01 August 2023

**Application Reference No. 2023/62/91491/W**  
**Proposed Development at Prickleden Mills, Woodhead Road, Holmfirth, HD9 2JU**  
**Impact on 29 Woodhead Road, Homefirth, HD9 2JU**

**Application Details** Erection of 61 age-restricted apartments with ancillary accommodation including separate residents lounge and manager facilities and associated external works, including the erection of access bridge and riverside walk featuring two pedestrian bridges (within a Conservation Area)

SECTION D-D 1:200

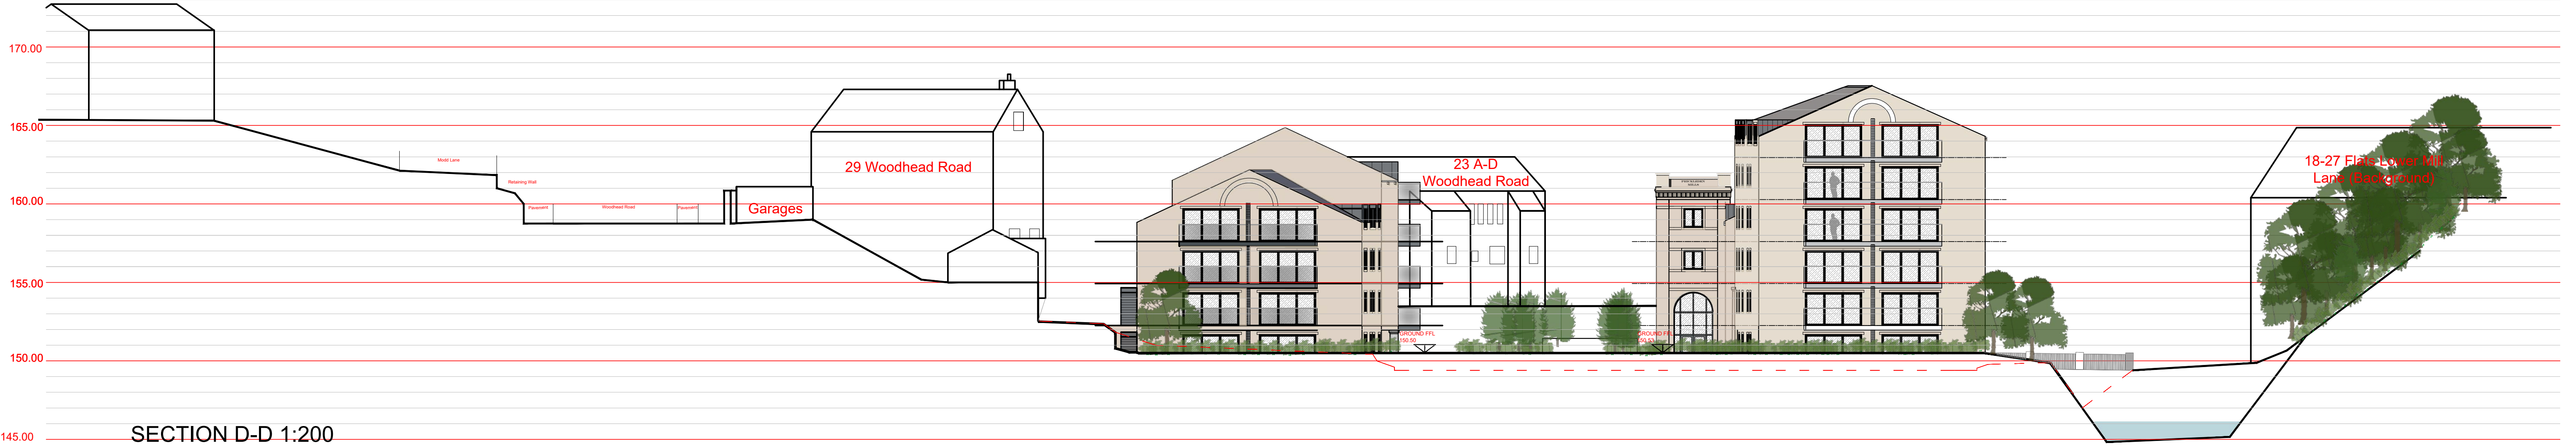
3. That the application of the BRE 25° test on section D-D does not reflect the position adjacent to our client's property.

You have presented the section G-G drawing (below for reference), which indicates that the proposal satisfies the BRE 25° test. I have copied below our section D-D drawing of the 25° test alongside for comparison.

Whilst I was unable to size the two drawings for an identical comparison - nor could I locate the cross section drawing G-G produced within any of the planning documents - when looking at the heights of both sets of balconies and the corresponding cross lines, it is clear that the midway point of the windows at 29 Woodhead Road appear to line up accurately on both cross sections. The proposal breaches the 25° test in respect of the two grey roof

dormers above the green line. (I've circled the two areas below in yellow for your ease of reference).

The section D-D also corresponds with the contextual drawing overlaid in red to show the prior proposal.

From the section drawing key below, it would seem that drawings D-D or F-F could be used to apply the 25° test. Section G-G too, although this is a slice section through the block and does not fully represent the proposal. The BRE Guide suggests that “If ‘any part’ of the new development crosses a line drawn at 25° from the horizontal, from the centre of the window, more detailed checks are needed. In order to pass the test, the whole development must be below the 25° line, not just the part of the development which is directly perpendicular to the centre of the window.”

For the reasons detailed above, we are of the opinion that it is reasonable to apply the BRE 25° test in relation to section D-D and that we've shown the proposed development breaches this test. Consideration of the more detailed daylight and sunlight tests is therefore required.
